COMMUNITY SERVICES DEPARTMENT

February 20, 2020

Subject: Riverbend Crossing Preliminary Plan (SP187)

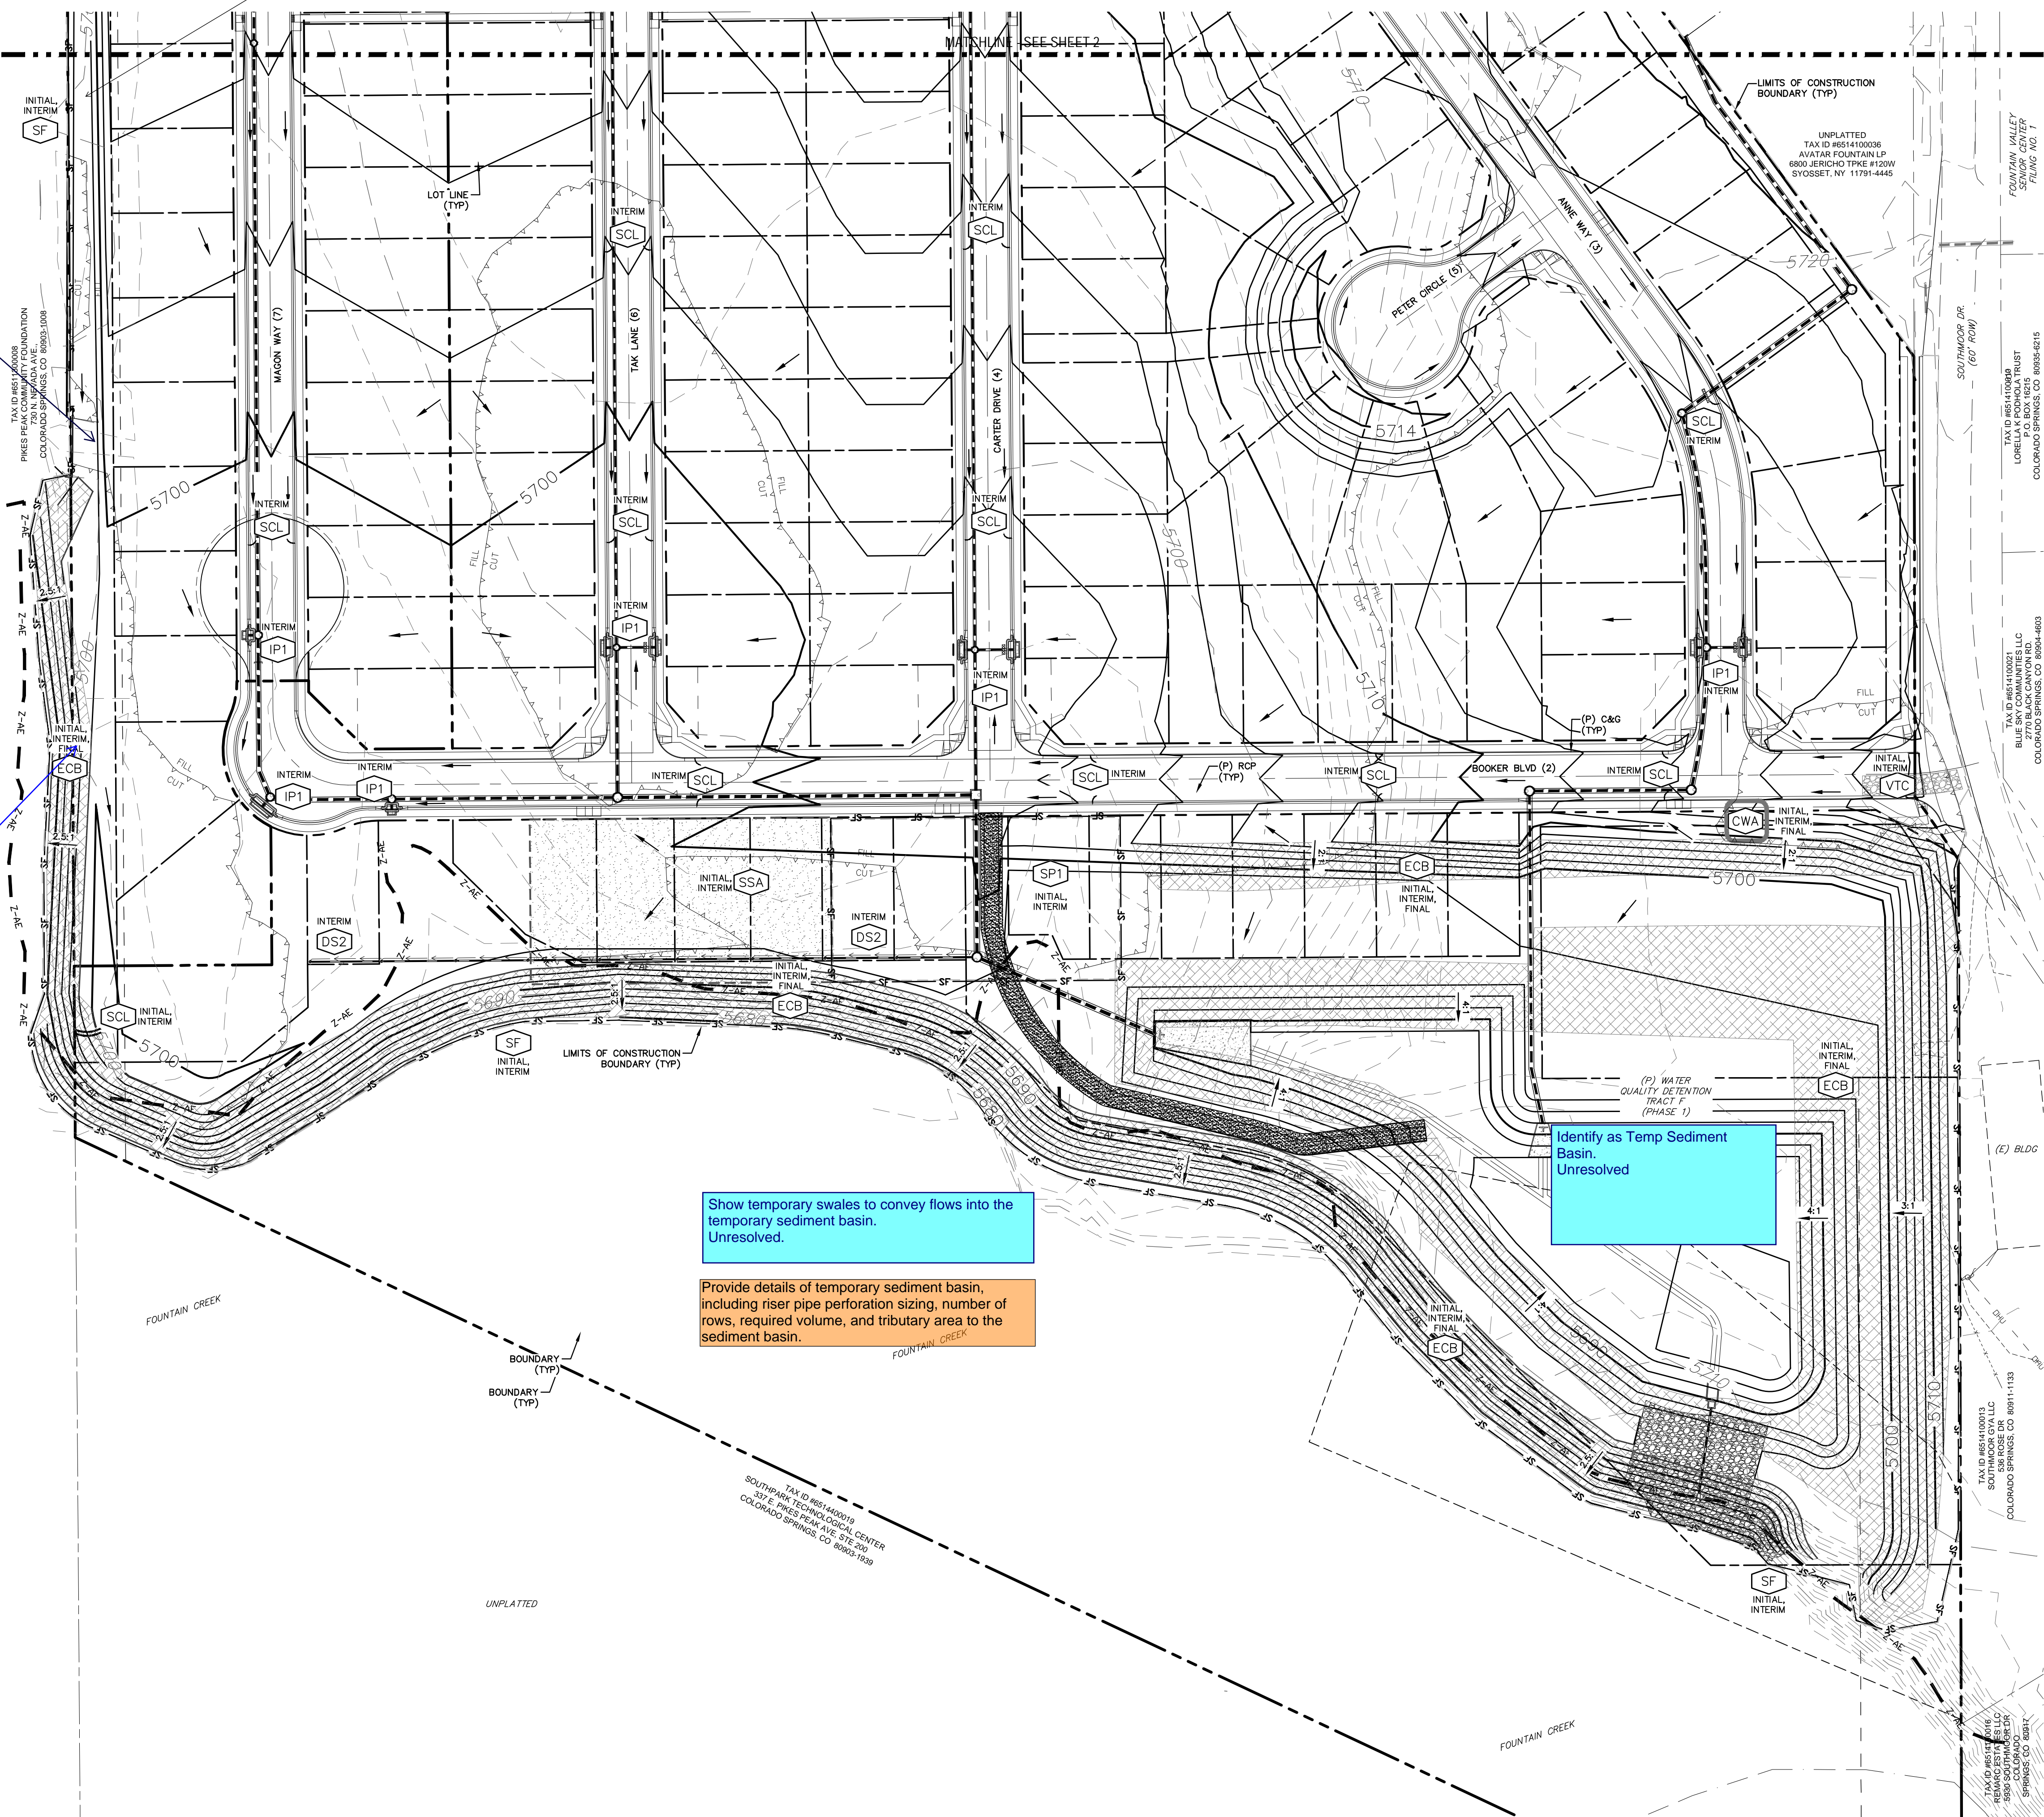
subdivision. Parks staff has concerns about how usable the proposed open space is since the preliminary plan drawings show most of the open space, or 12.54 acres, is identified as site detention. This would not be considered usable open space for residential recreation opportunities. Other proposed open space includes a thin 15-ft landscape buffer from the adjacent commercial development, Tract A which features a steep bank, and a 35-ft no-build setback from Fountain Creek. Parks staff encourages the applicant provide usable open space and recreational amenities for the future residents of the proposed subdivision. Parks staff suggests a small pocket park / trail system be included within the proposed subdivision and shown on the preliminary plan and subsequent final plat drawings.
